DRB Application No.: 05DRB-01687 (P&F)
Project Name: EL POTRERO PROPERTIES
Agent: Isaacson & Arfman PA

CITY OF ALBUQUERQUE
Planning Department
November 9, 2005
DRB Comments

PROJECT # 1004434 APPLICATION #05-01687

RE: Tract A, El Portero Properties/minor pp & fp

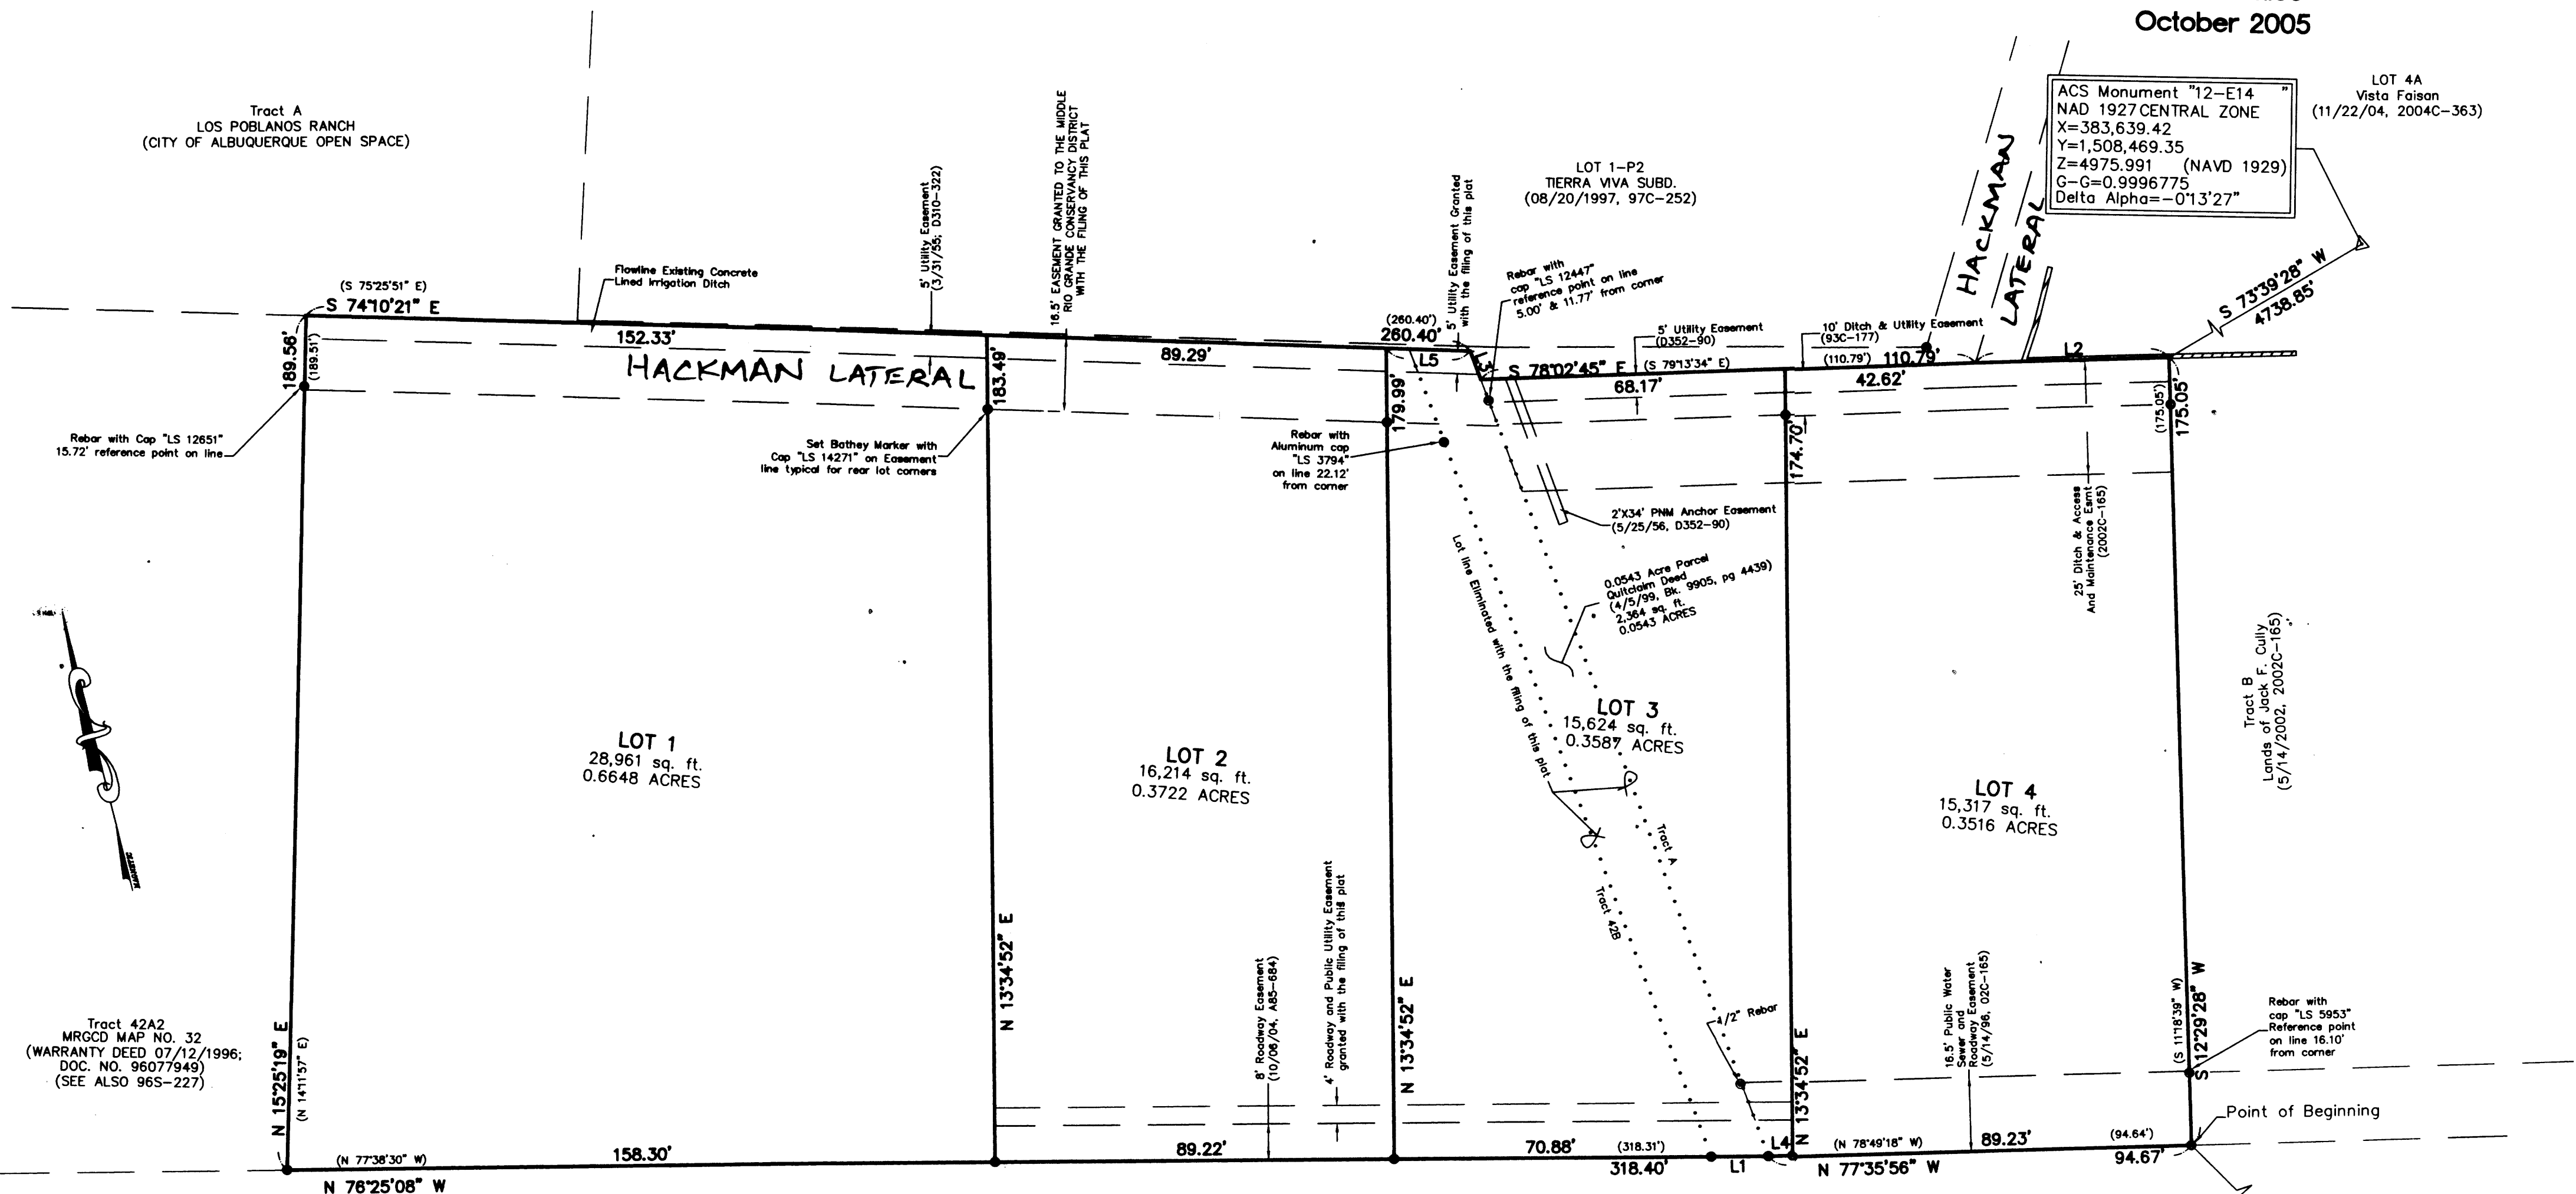
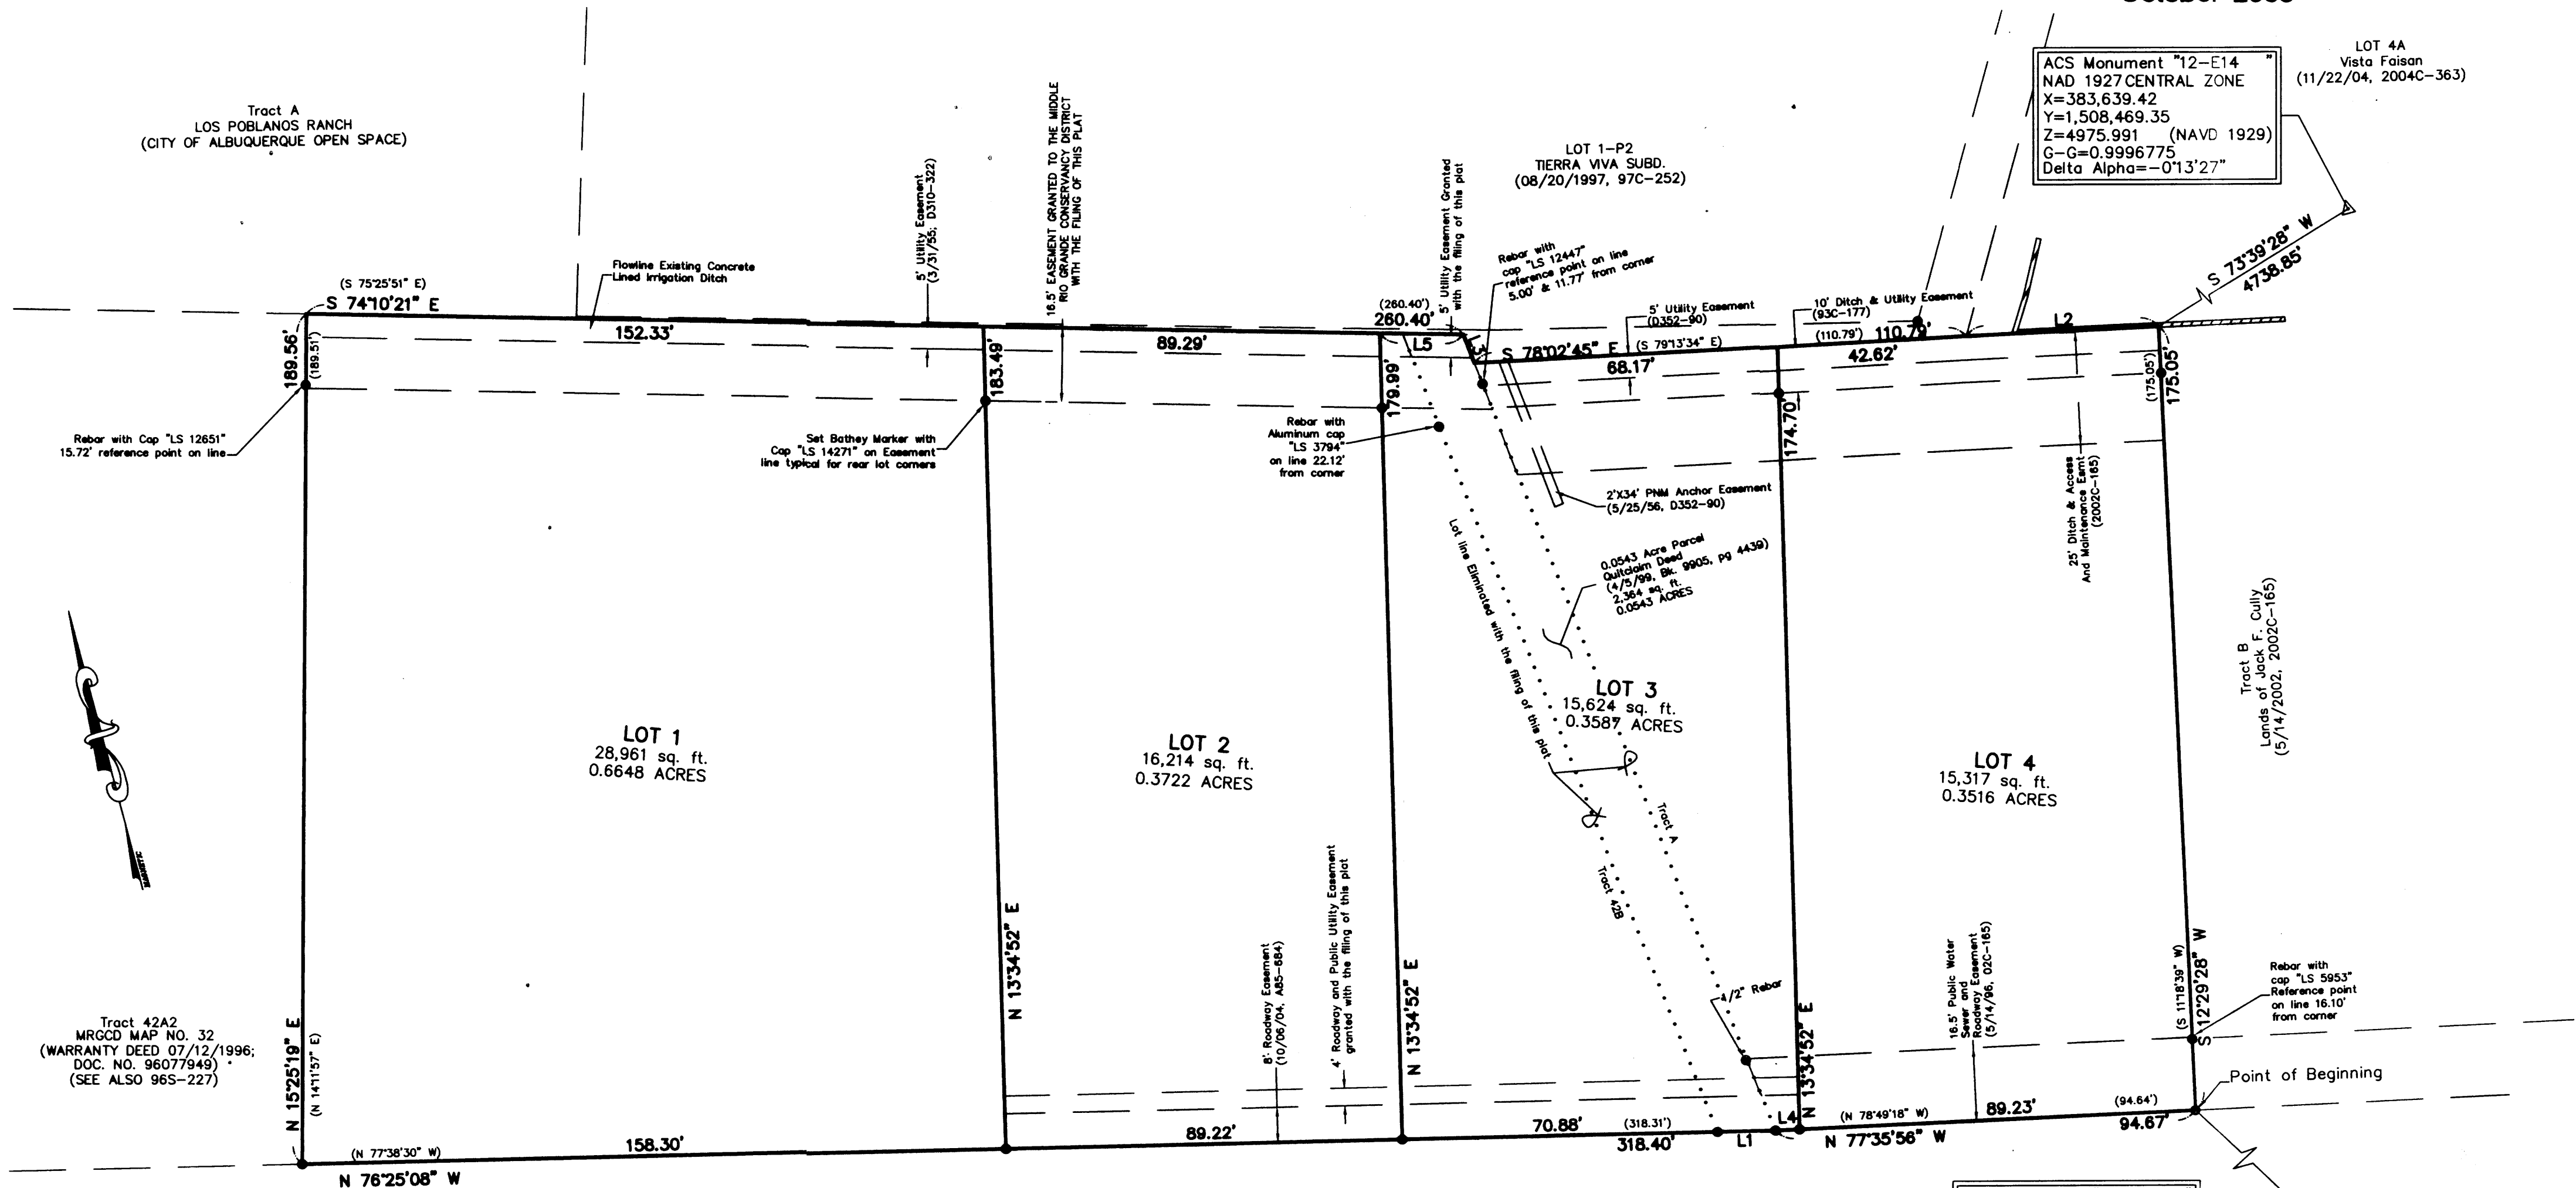
There is no Zoning information in the subdivision data block.
